From: Amanda Scholes on behalf of Planning.Responses
Sent: 09 January 2020 12:23
To: Planning Scanning
Subject: FW: Planning Consultation on: BN/57/19/RES

Comment from Greenspace

APPLICATION NO: BN/57/19/RES

Description of Works: Approval of reserved matters following the grant of WA/22/15/OUT for a 2 No. non-residential buildings.

Client Rural Associates Project Title and Location GTR Factory Arundel Road, Fontwell, West Sussex	Drawing Title Detailed Planting Plan Ornamental Planting
Scale 1:100@A1	Drawn EZ
Approved DW	Date 30.01.20
Drawing No LLD1773-LAN-DWG-201	Revision 02

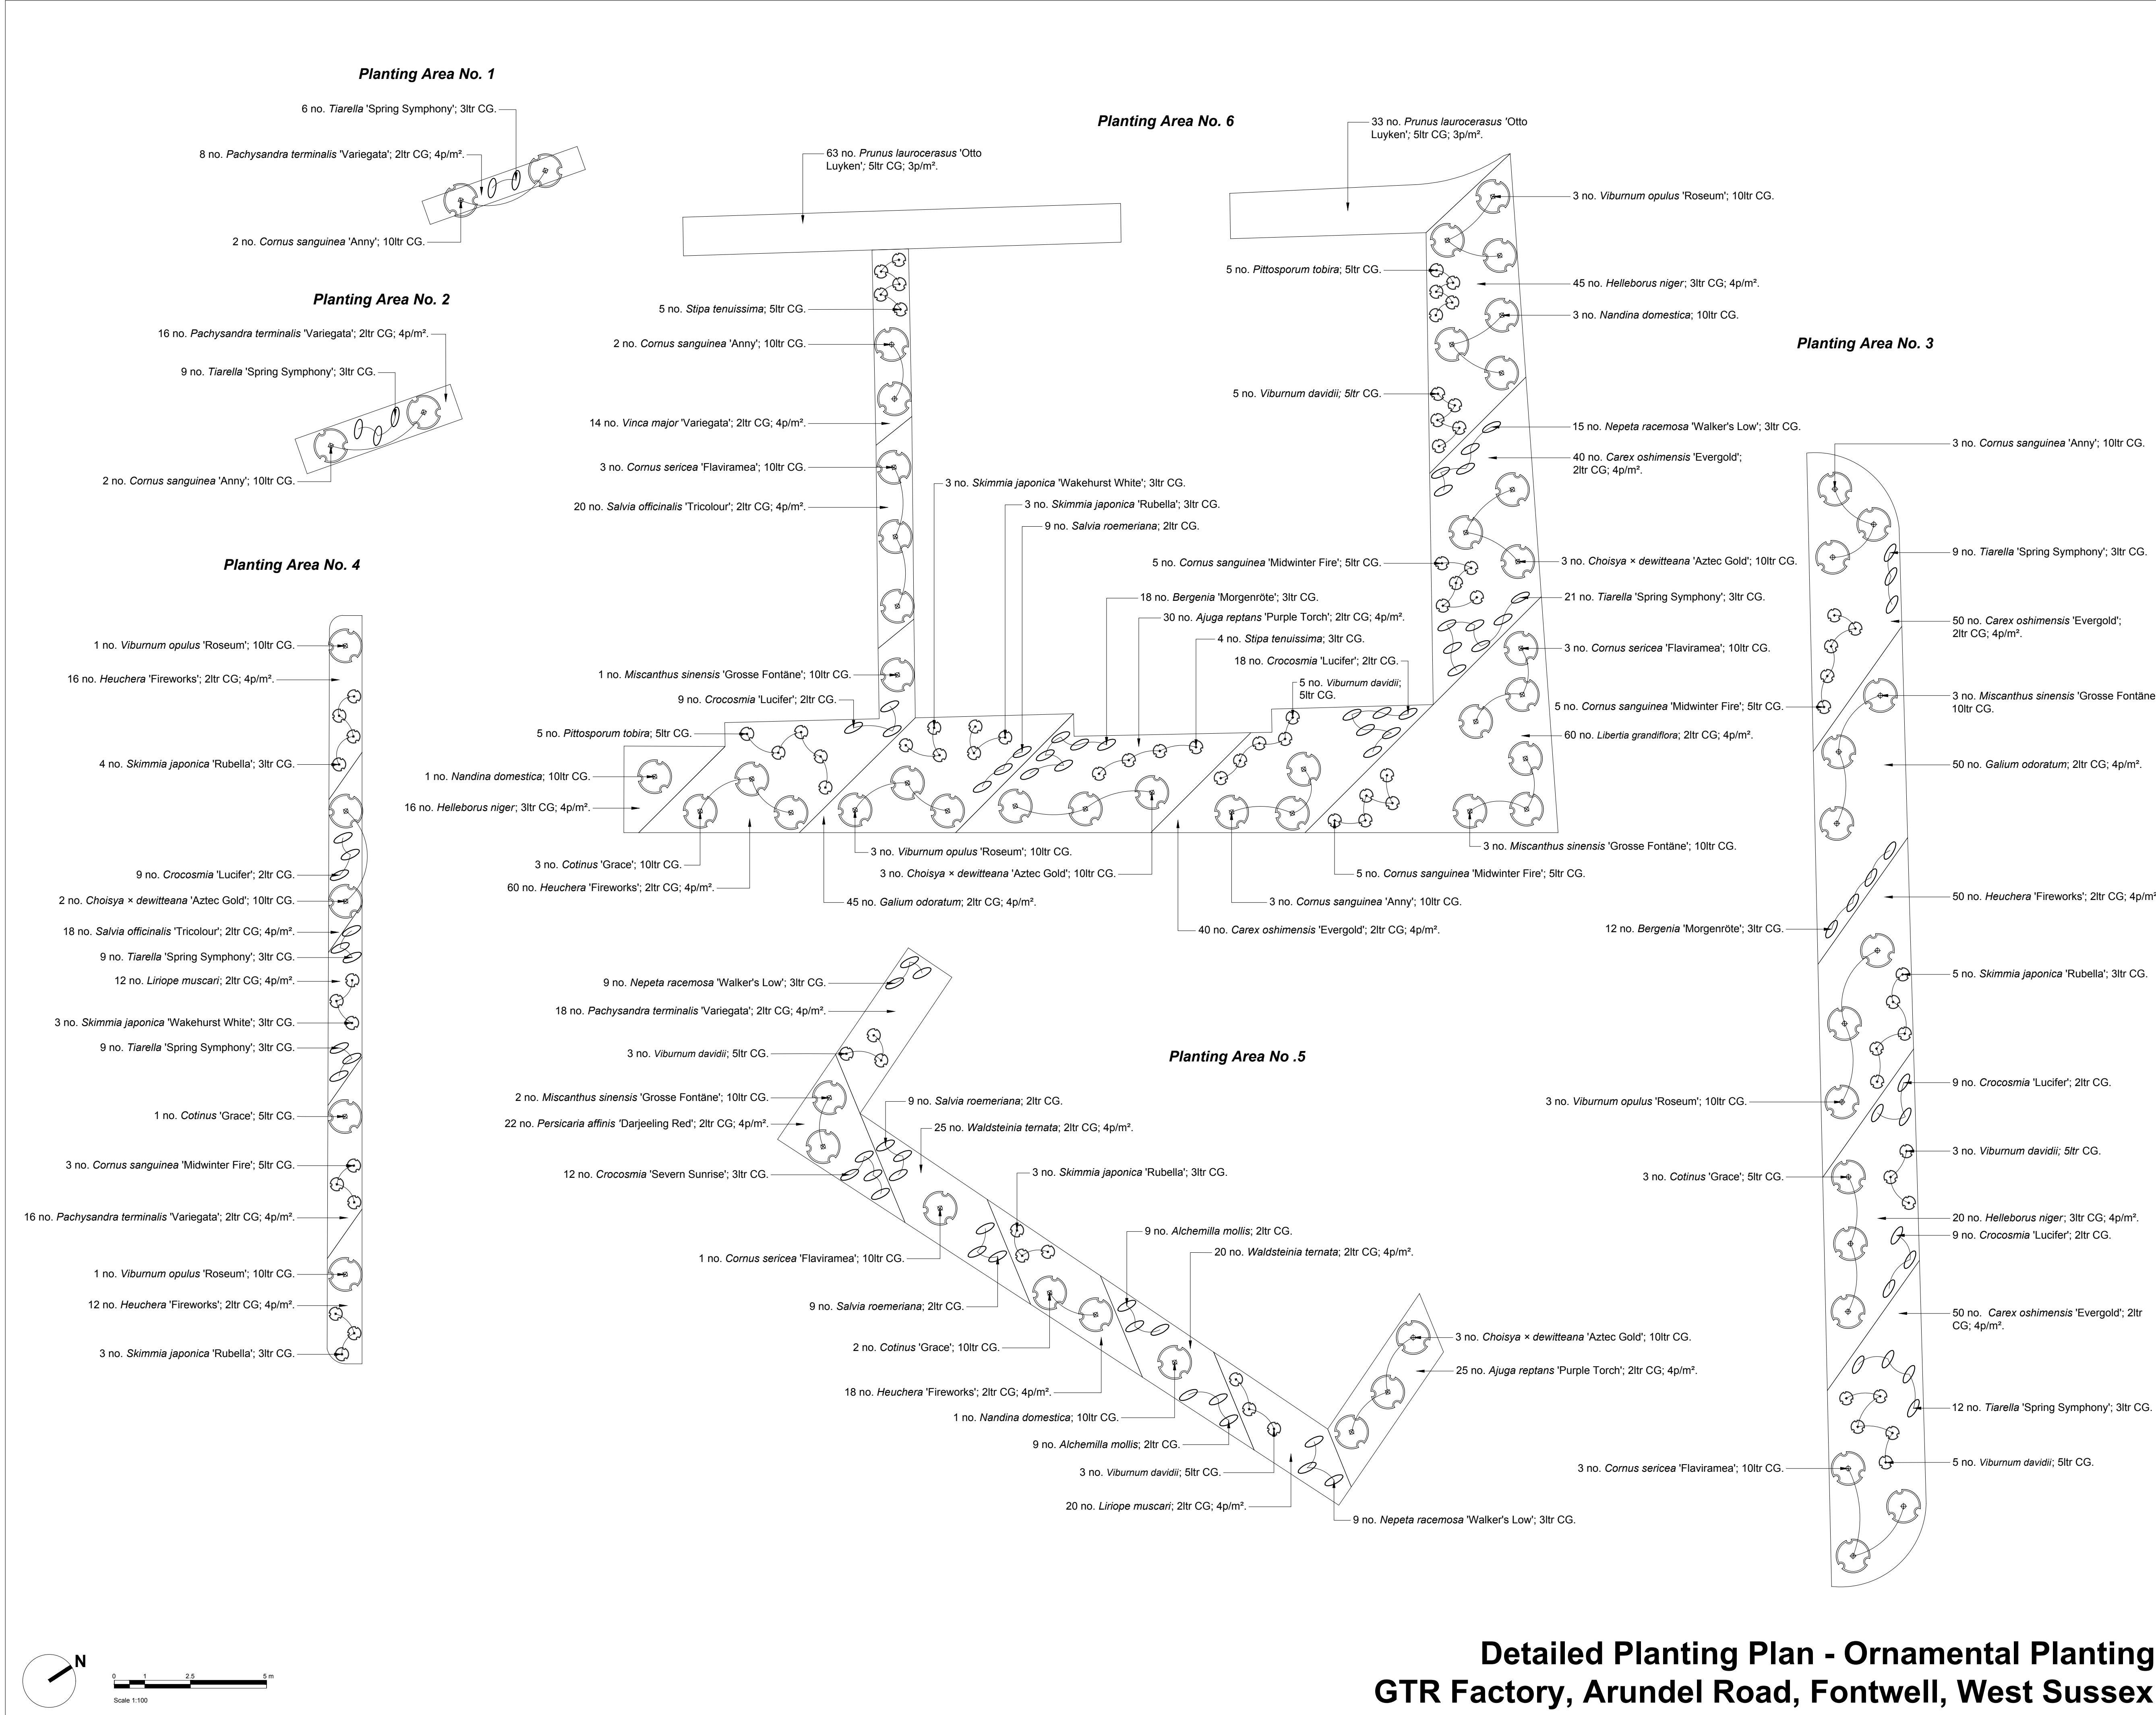
The information submitted under this Application BN/19/RES does not appear to have included any landscape detail relating to the proposed 2no non-residential buildings or their surrounds. There will need to be submitted a full landscape scheme detailing hard and soft landscaping and referencing existing features, trees and shrubs to be retained. There will need also to be a tree report to show interface with existing trees and those to be protected and retained, both during construction and ongoing.

A full landscape scheme in plan form, detailing plant species, actual numbers, spacing and proposed size at time of planting will need to be submitted for approval. The scheme will need to be sympathetic and fitting with that proposed under WA/22/15/OUT for the master planned area. The landscape scheme will need to provide a good mix of natives and ornamentals with both evergreen and deciduous species to tie in with the existing to be retained vegetation and significant trees in this location. It should provide biodiversity benefits and not compromise the existing green form in this corner of the site.
